Response to Planning Application

From: Arun District Council Greenspace

Application ref: CM/17/21/PL

Description: Development of 2 No. 2-bed & 2 No. 3-bed detached dwellings & associated works (resubmission following CM/53/20/PL).

SITE PLAN
SCALE 1:500 @ a3

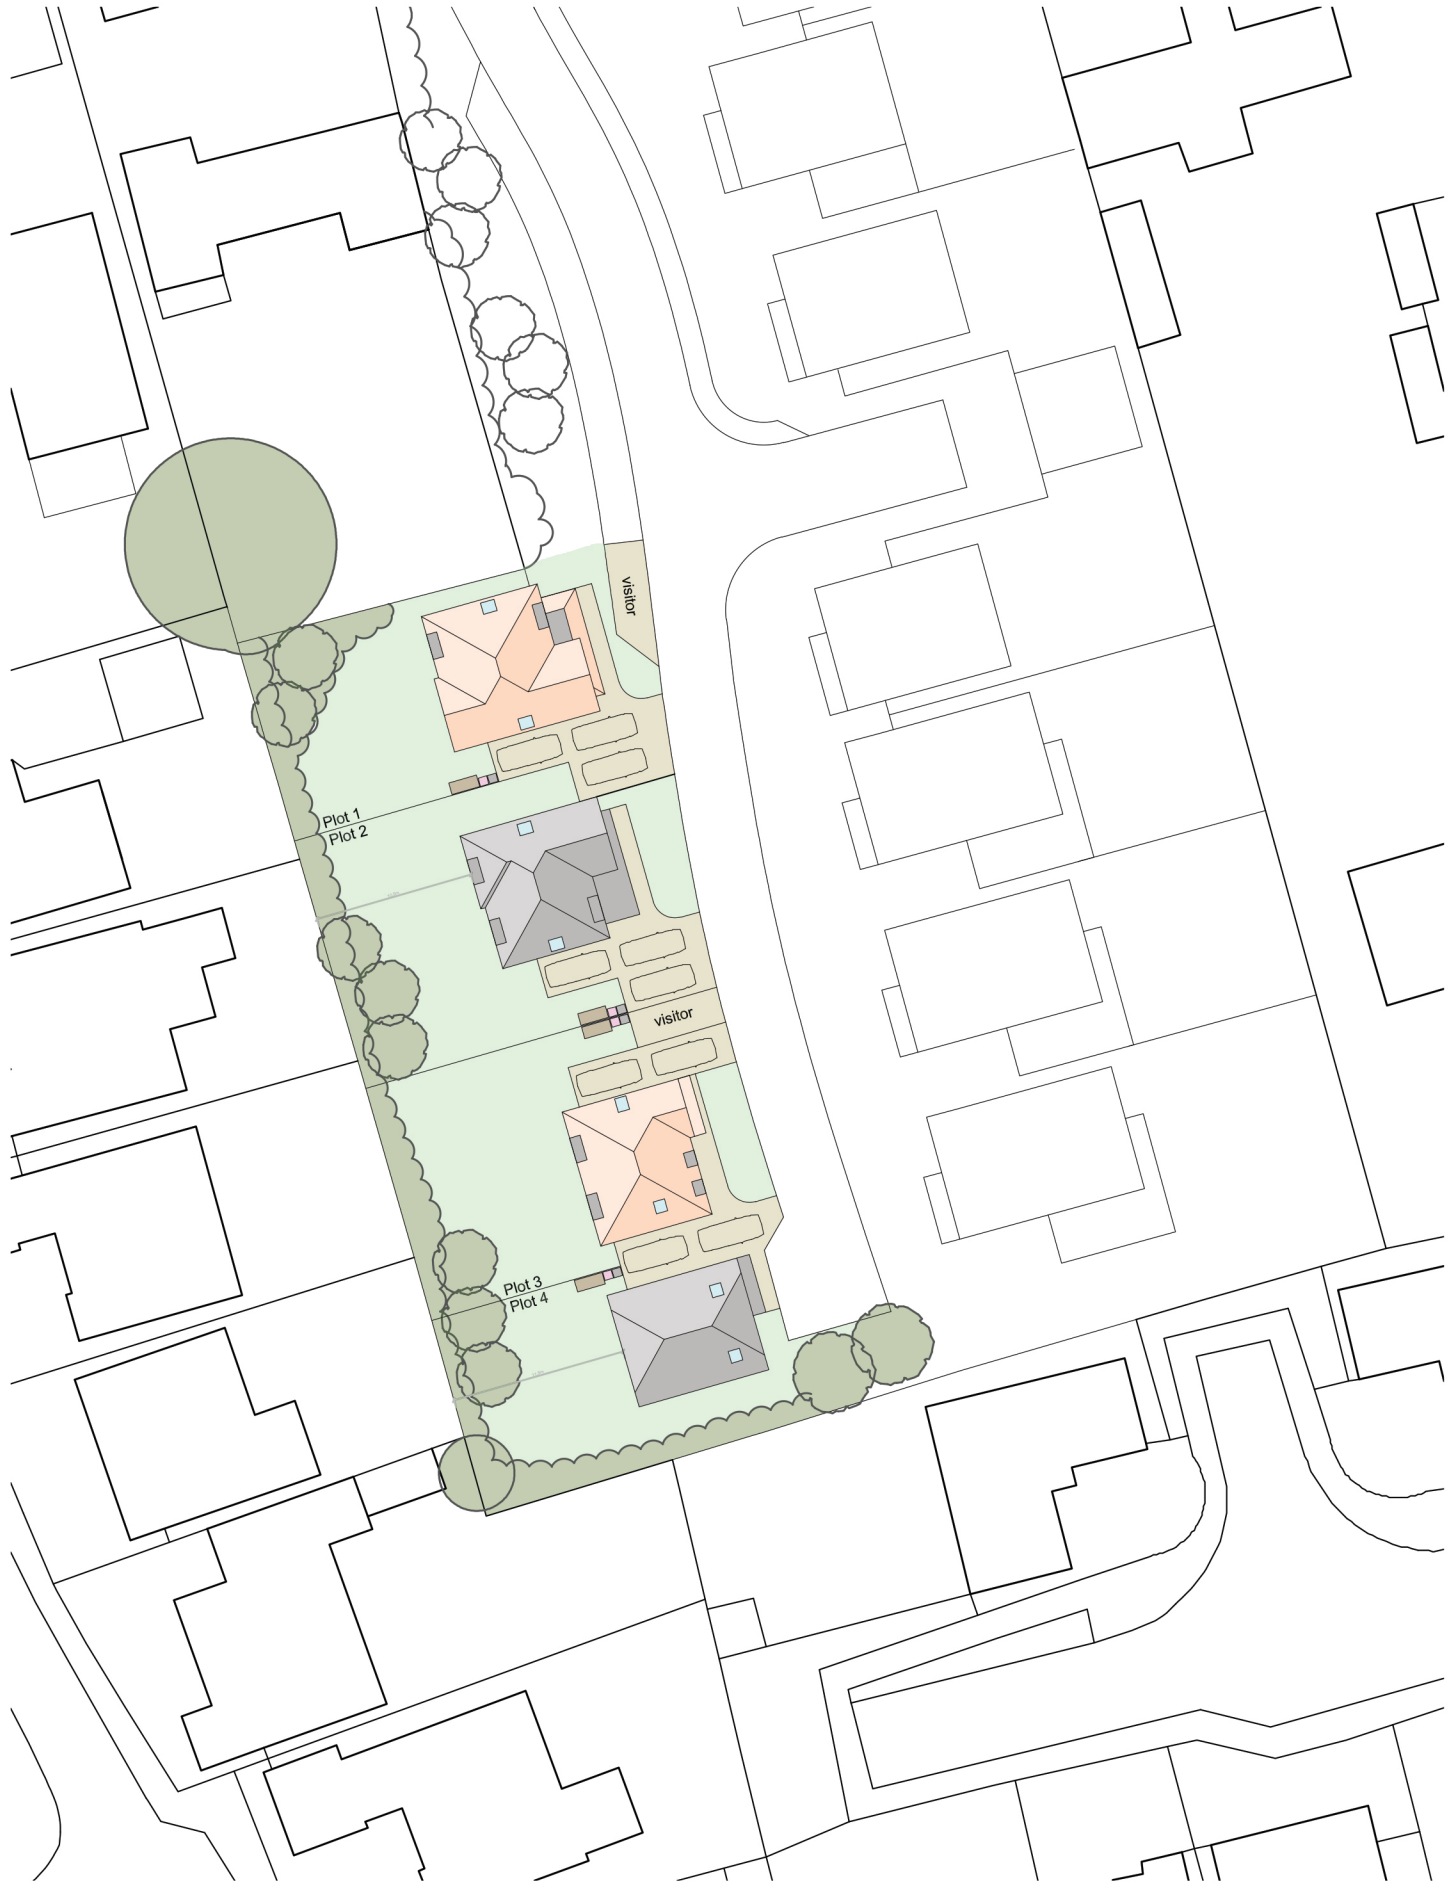
The NPPF para 124/127 relate to good design principles. The indicative location plan has suggested the retention of existing vegetation and inclusion of new landscaping to this development which would be required to be submitted and approved. The inclusion on new landscaping for these proposals should be in consideration of greening and screening and should also consider the biodiversity net gain requirements to be achieved with this development.

The potential impact of the proposals, whilst could be viewed as over development of the plot, could be blended into the surrounding environment with further thought given to the landscape offer and greening to counteract this. Screening to adjacent properties will need to be considered because of their proximity and stature in relation to the proposals.

Further landscape provision to the roadway and accessible areas and incorporation of screening to adjacent properties with the incorporation of planted areas for trees and shrubs. The green boundary treatment to include tree species. All areas should be considered and their connection for biodiversity and habitat explored. Trees specified should be at a size which allow instant impact, but which will establish and mature as the site develops.

I would recommend **no landscape objection** subject to the submission of a detailed landscape scheme. Landscape detail to be submitted in plan form to show existing to be retained and new planting detailing species choice, actual quantities, planting densities and size at time of planting.
